From: Kevin Patton <Kevin.Patton@PulteGroup.com>
Sent: Wednesday, December 18, 2019 9:13 AM
To: Cherne, Curtis; Yolanda Padilla Moyer; Roeder, James A.; Biazar, Shahab
Cc: Adeeb, Muhanned W
Subject: RE: Del Webb 3A

I have reviewed the Design Revision sheets 6R and 15 (should be 15R) as well as the drainage report stamp date 6-14-18 and the Amendment 1 labeled January 23, 2019, but stamped 1-23-18 (yes, 18, think off by one year) and provide the following comments:

CITY PROJECT NO.	ZONE MAP NO.	SHEET	OF
650482	H-8/9	5R	26

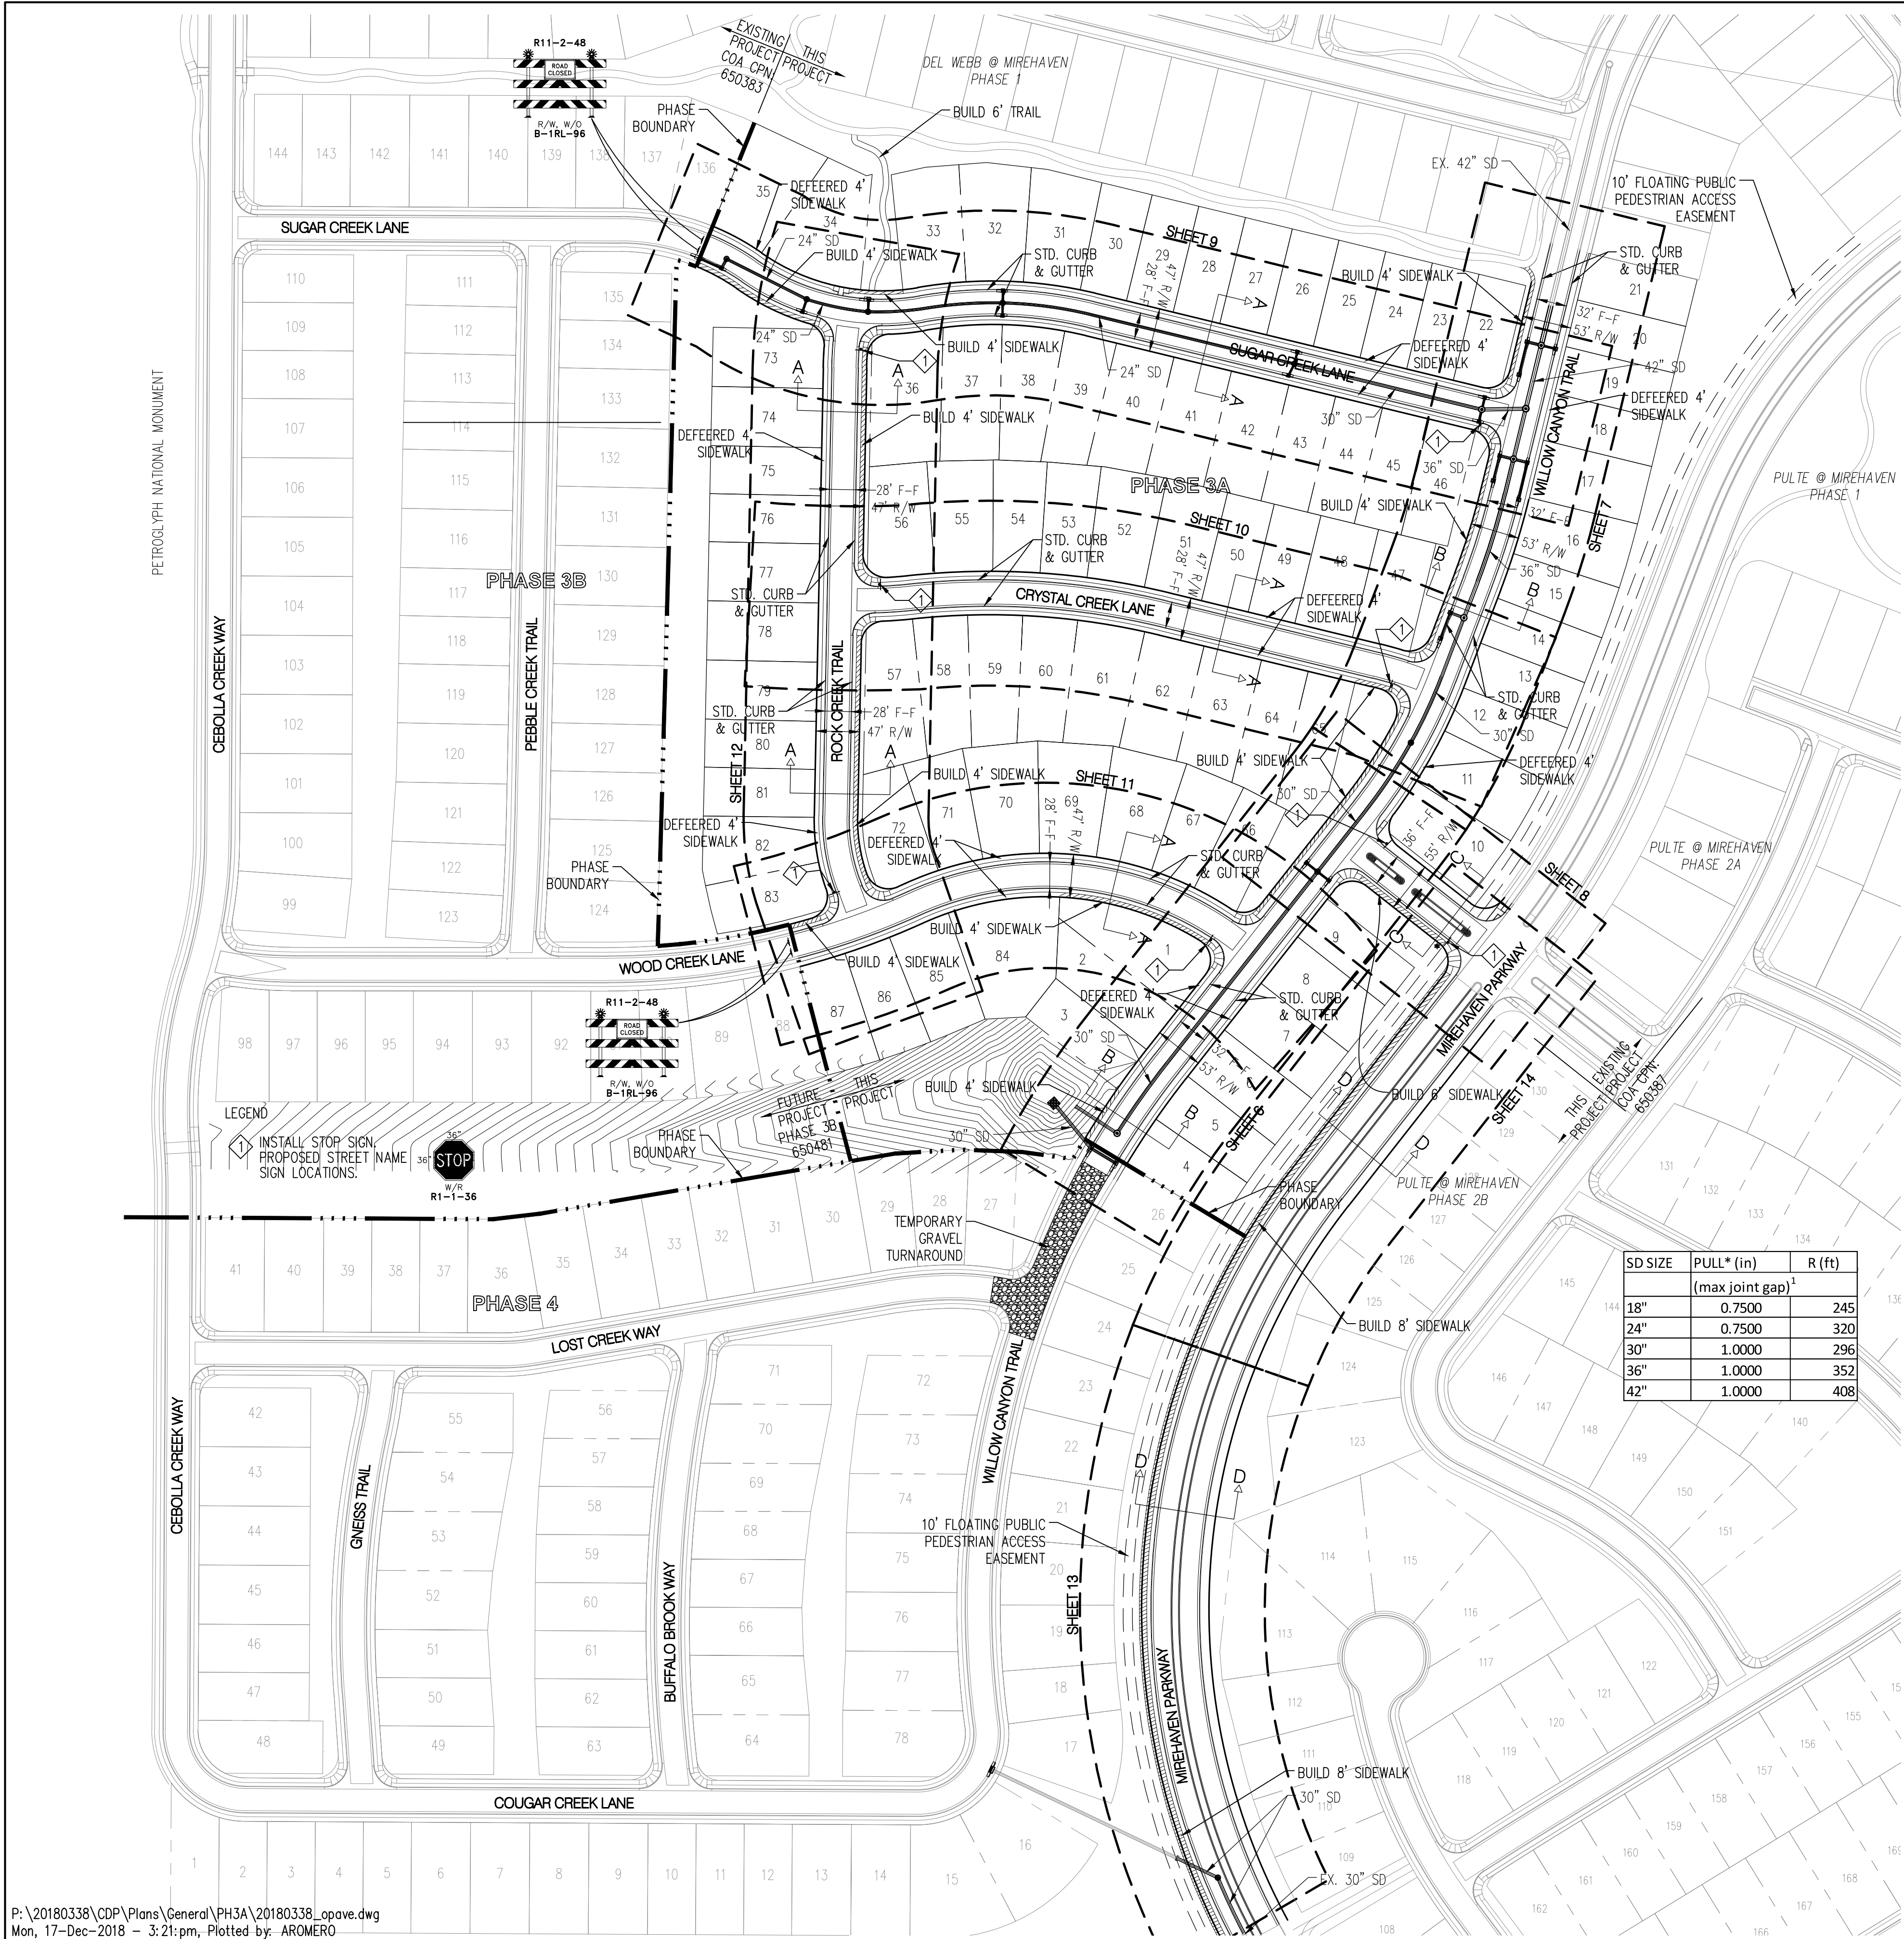
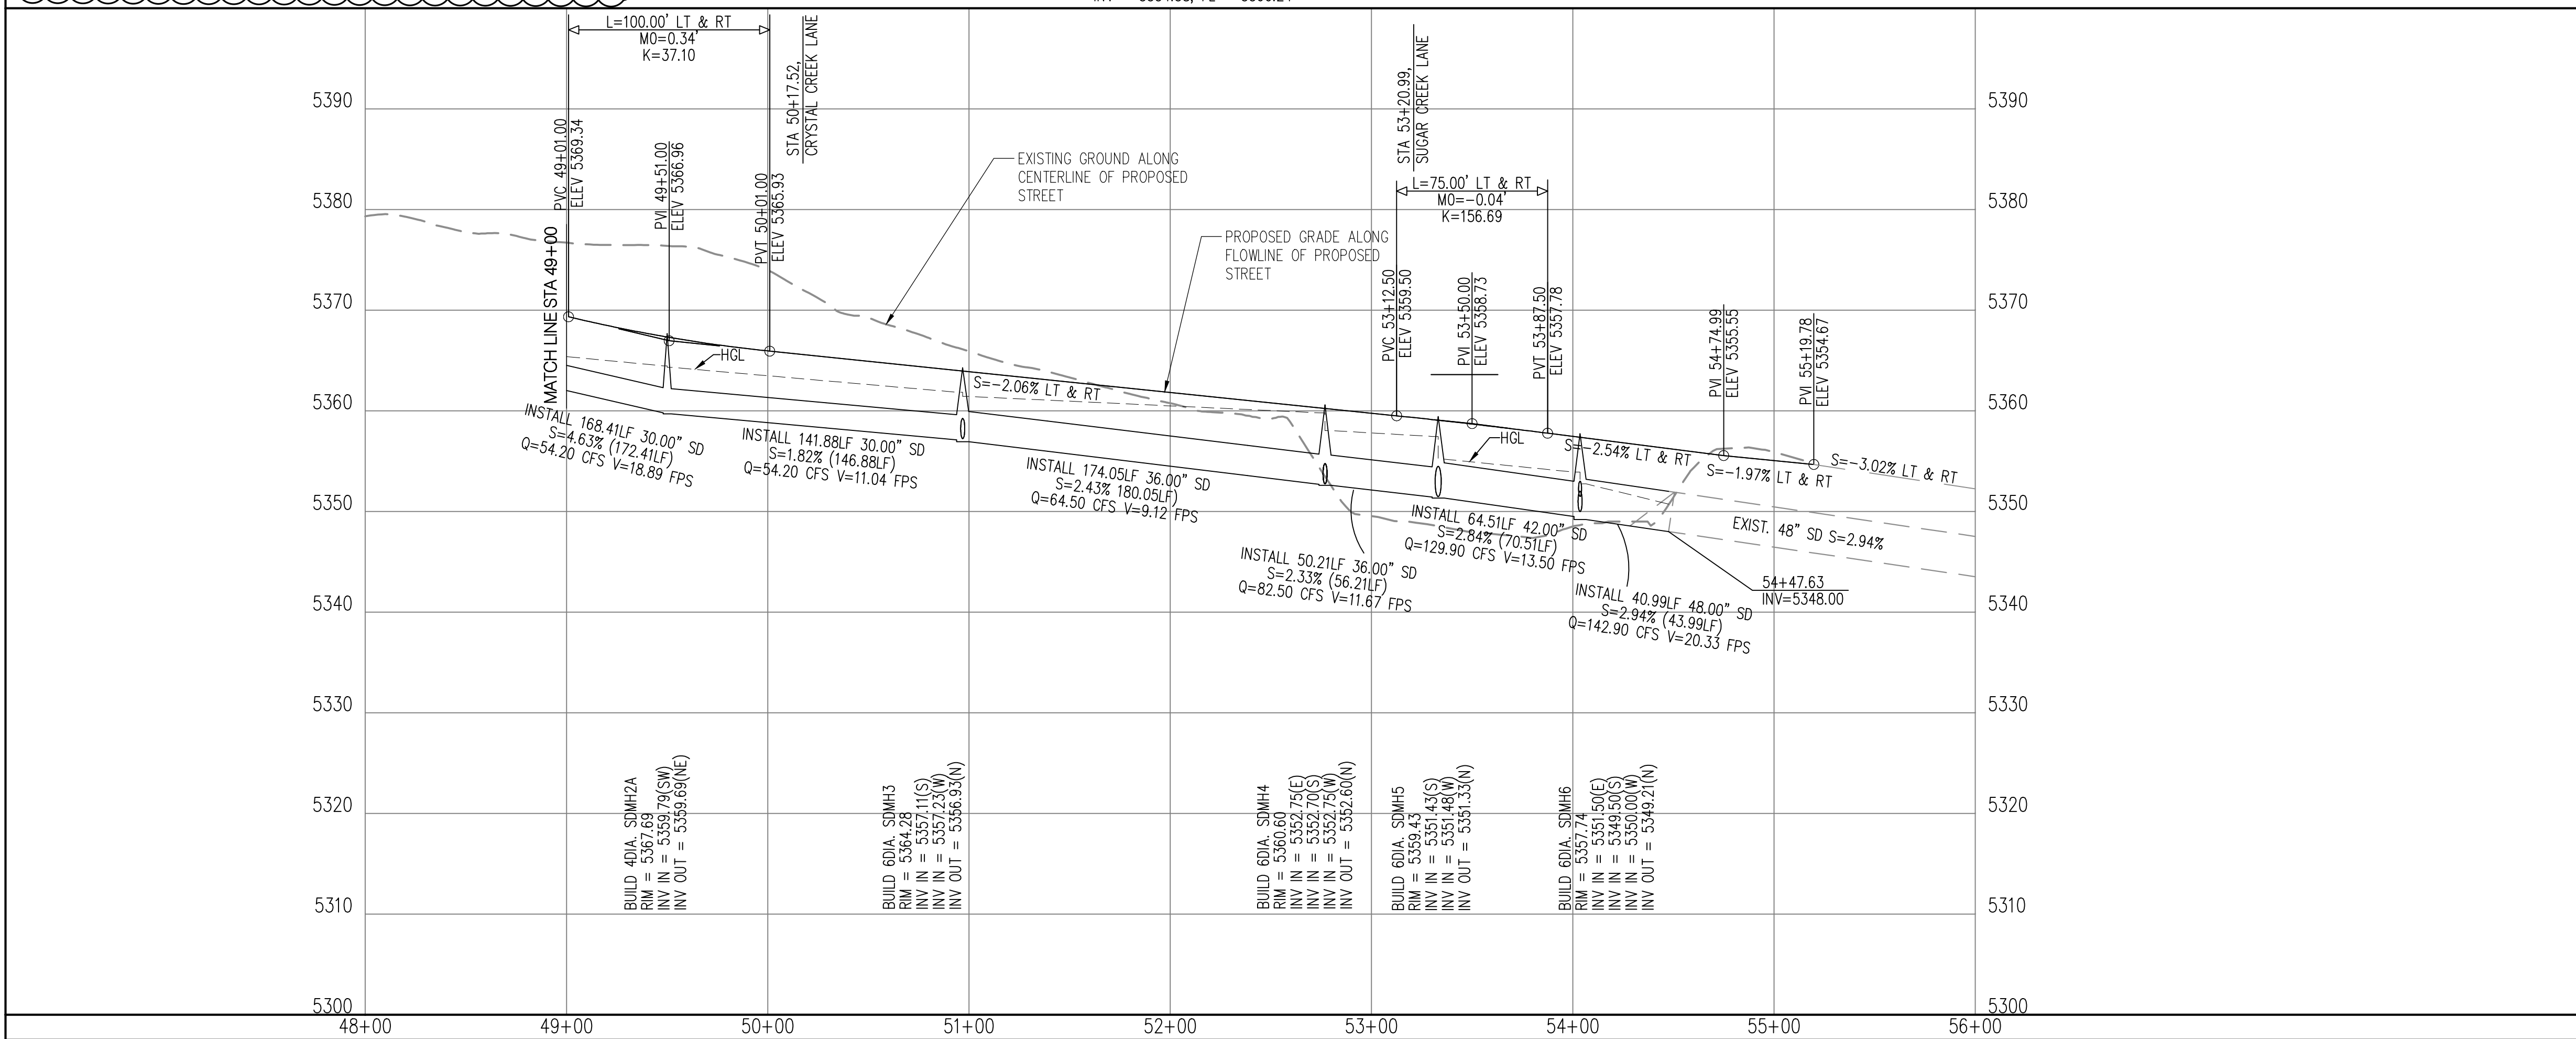
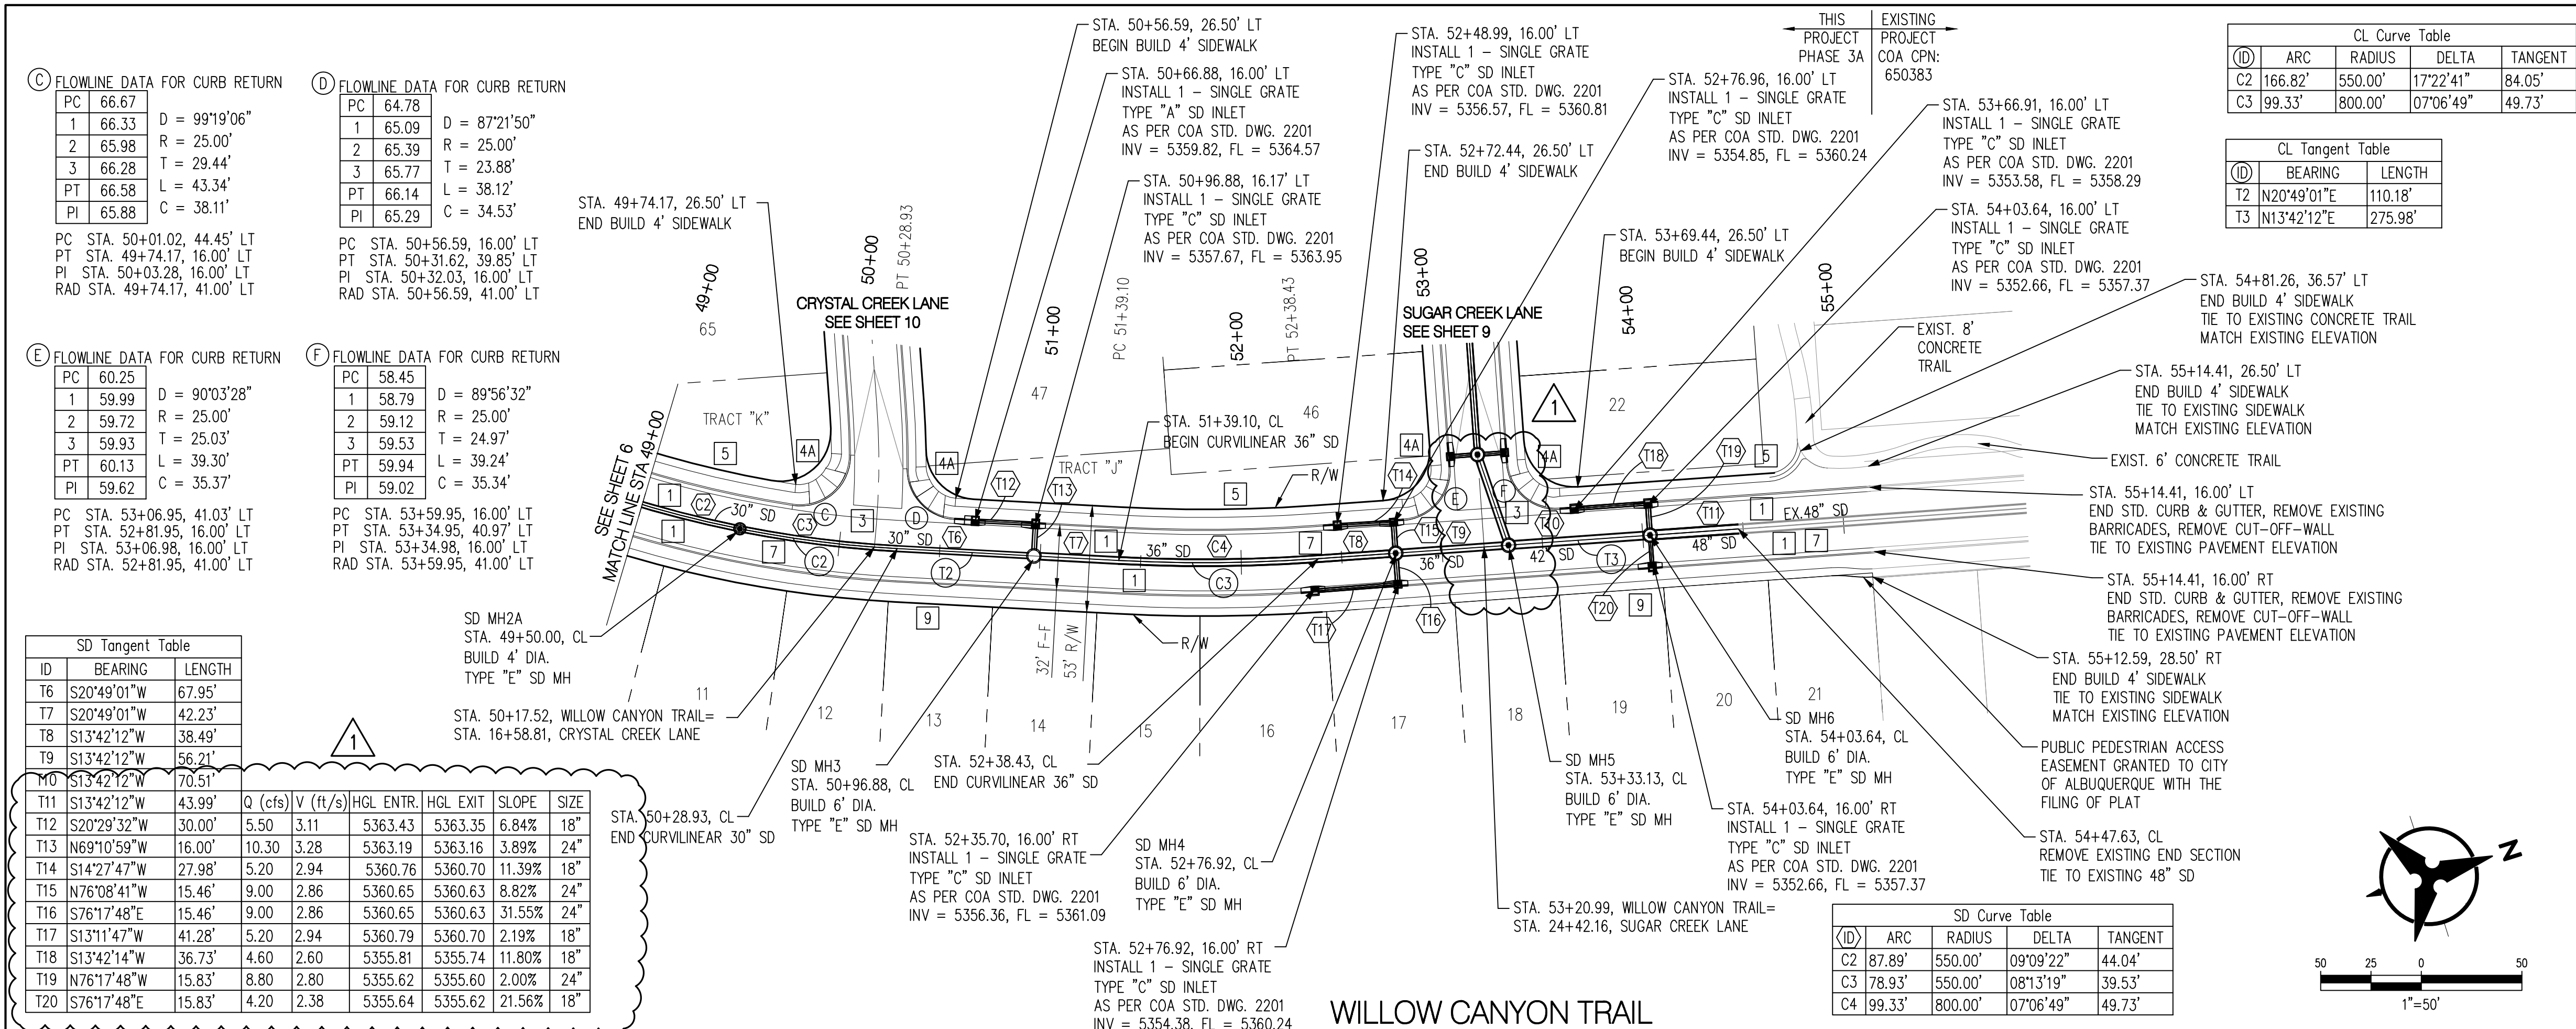
2. Comments on Sheet 6R:

- a. Show inlets and drain pipe on profile STA 43+90 or so. Pipe needs Q,V HGL. If not enough space on the plan, you could show this on Sheet 15R. Depending on Q and V, riprap pad may be inadequate. I did not see calcs for sizing riprap pad in the drainage report. **Q, V and HGL are provided on all SD pipes. The Q coming out of the sd is only 8.8cfs. The 10x10 pad is adequate.**
- b. For the inlets: delete FL elev and replace with TC elevation. **Inlet are built so I don't see the point in updating now.**
- c. Remove "Temporary Pond" near top of sheet. **Will crossout or relabel in the asbuilts**
- d. For the pipe draining the pond, change "1-24 flared section" to "1-30 flared section" as it is a 30" pipe. **Can be corrected in the asbuilt drawings.**
